Landscape Review

*of the*  
**M3 Junction 9 Improvement**

*Prepared for*  
**South Downs National Park Authority**

*PINS Reference*  
**TR010055**

FIGURE 8A
Tree Removal Plan &
LVIA Viewpoints

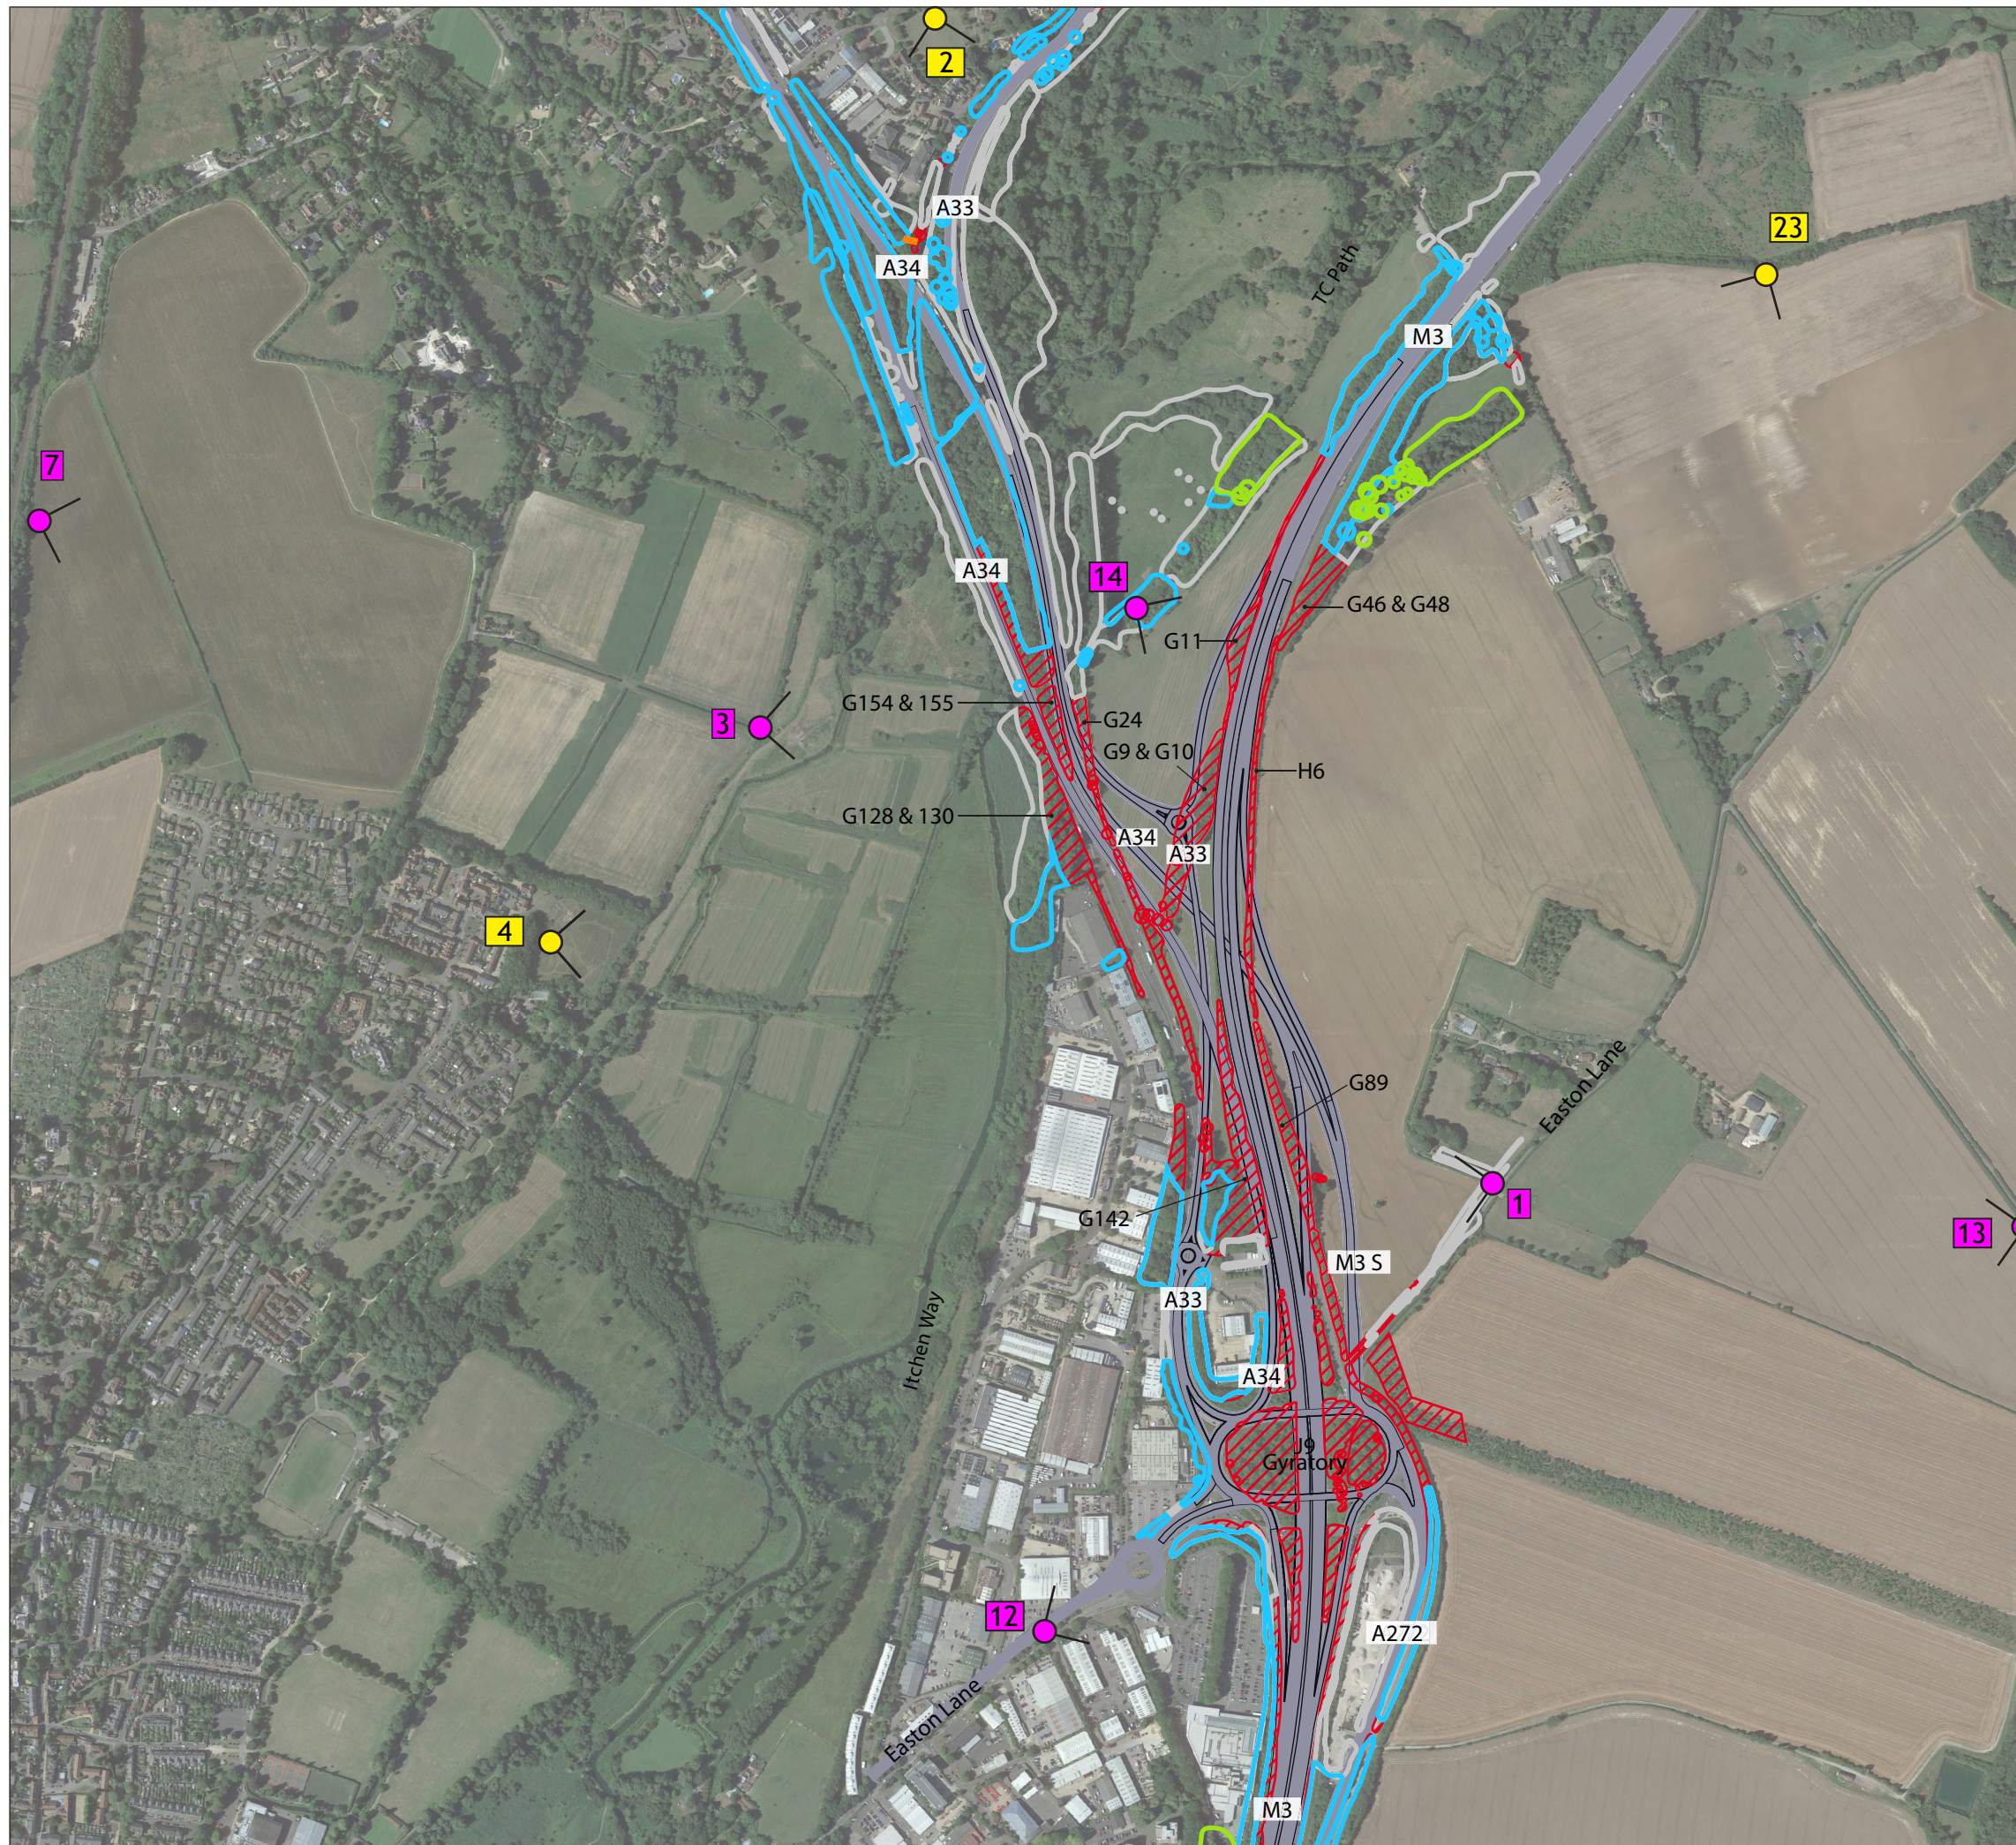
- 1.19 The effects have been underestimated in the LVIA chapter and they are also underestimated in the accompanying visualisations submitted by NH which form part of that assessment. The visualisations fail to accurately show the loss of vegetation. We identified that this was the case for Vp 14 and the revised Vp 14 submitted at Deadline 1 (REP1-010<sup>7</sup>) has confirmed that the tree removal had not been shown. We have now reviewed the other visualisations and there is a more significant failure to show tree loss from Vp 3 and Vp 7. NH have said that they are reviewing the visualisations and will submit new visualisations for Deadline 3.

- 1.22 The SDNPA disagrees with the conclusion with regard to the effects from Vp 3, that at year 15 the magnitude of change would be negligible. Trees to be removed cannot be fully mitigated and traffic on the new sections of slip road are likely to be visible from St Swithun's Way.

FIGURE 9A
Environmental Masterplan & LVIA Viewpoints

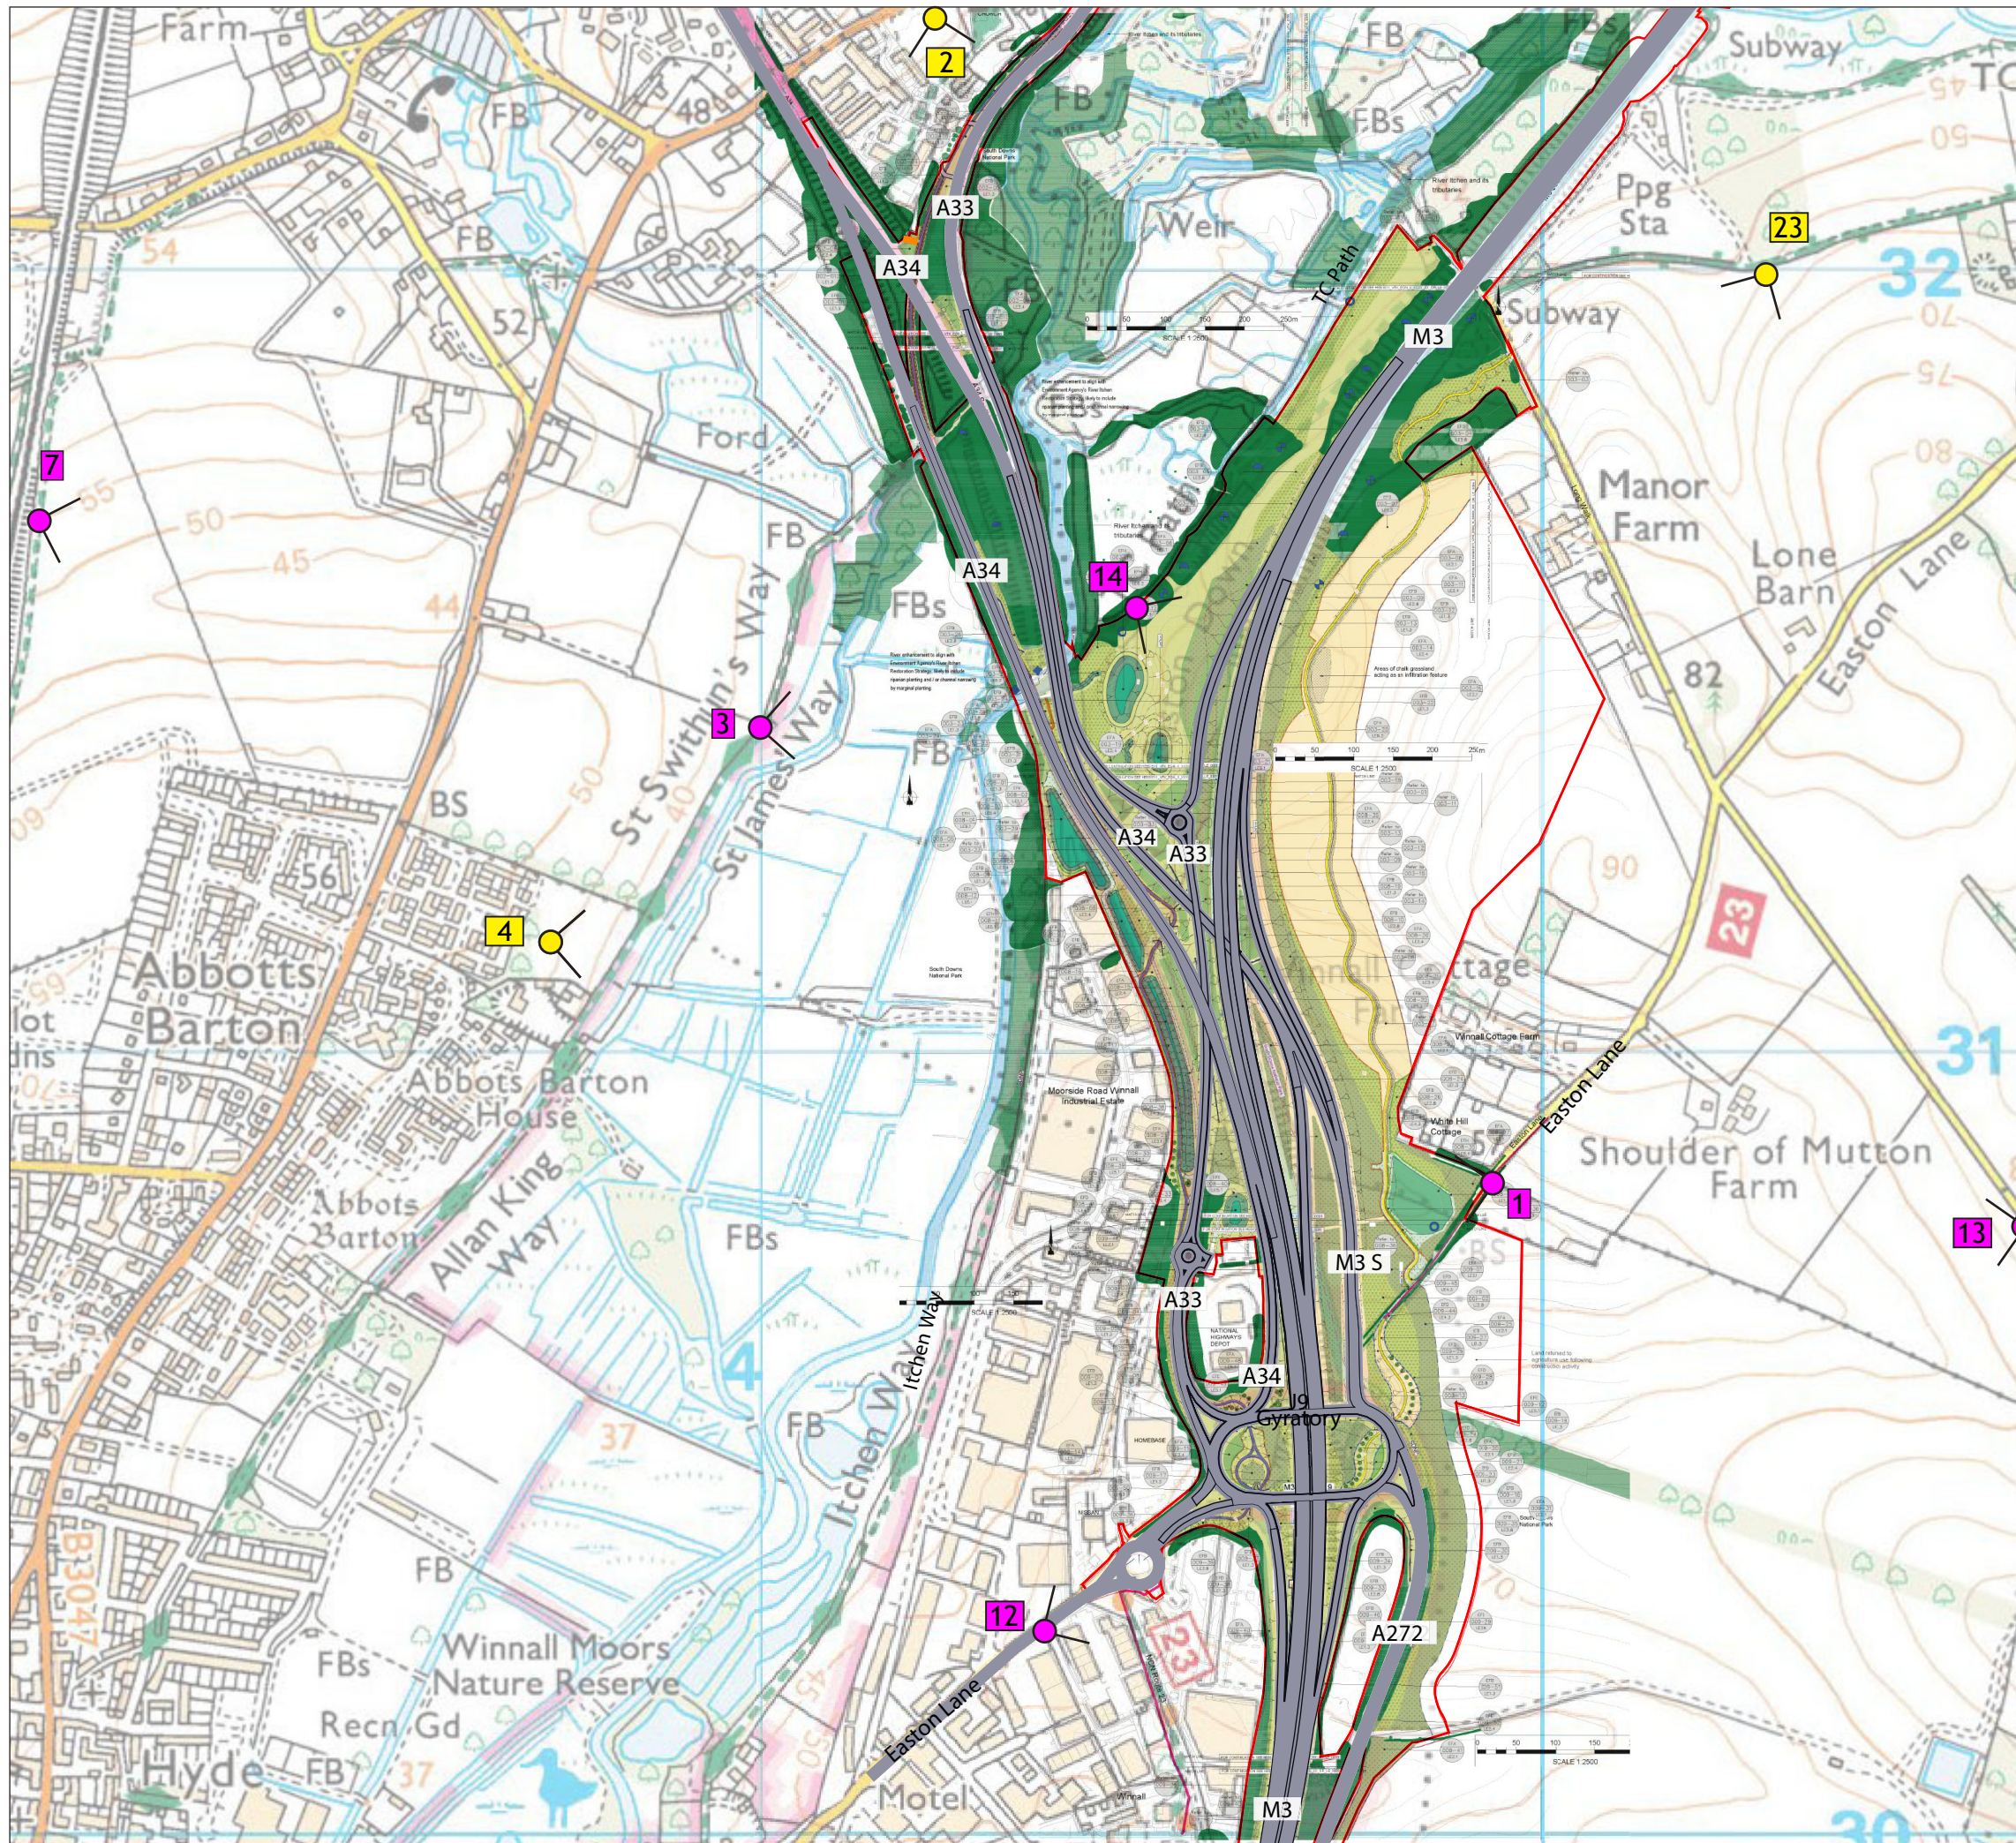
Issue 3: Proposed vegetation (Figure 9)		
<p>Proposed tree planting alongside eastern edge of the M3 is unlikely to be sufficient to provide a robust level of screening of the road infrastructure and activity, particularly in the short term, for people within the SDNP.</p>	<p>Tree planting along the eastern edge of the motorway is no less than 25m in width and at least half of this planting occurs on top of the cut batter where it will be more elevated and will provide more effective screening.</p>	<p>n/a</p>
<p>Proposals for planting / vegetation management within land between the A34 and M3 are not adequate to mitigate impacts on the valley landscape and amenity of PRoW users.</p>	<p>Utilise this area to accommodate more tree planting which would help mitigate the visual impact of the proposals on people using the PRoWs within the Itchen Valley.</p>	
	<p>Additional tree planting would encroach on proposed chalk grassland. This would require an extension of the chalk grassland. (See Issue 7 below).</p>

<b>Chalk Grassland</b>		
<b>Issue 7: Chalk grassland &amp; farmland interface (Figure 9)</b>		
Proposals for chalk grassland within the landscape east of the M3 will establish a new sub division within the open downland. It is unclear how the chalk grassland will be protected from agricultural activities and management practices which might erode the chalk grassland.	Fields east of the M3 should be treated as one, and all reverted to chalk grassland.	n/a
<b>Issue 8: Chalk grassland on embankments and areas of fill material (Figure 9)</b>		
The chalk grassland on cut batters is likely to be difficult to access and manage to achieve the establishment and long-term success of chalk grassland that is species rich. This is due to the woodland and scrub proposed for the higher parts of the slope, the fragmentation of the areas of proposed chalk grassland and the location/gradients which will make scrub management difficult.	Review and extend the proposed woodland and chalk grassland planting. (See Issue 9 below).
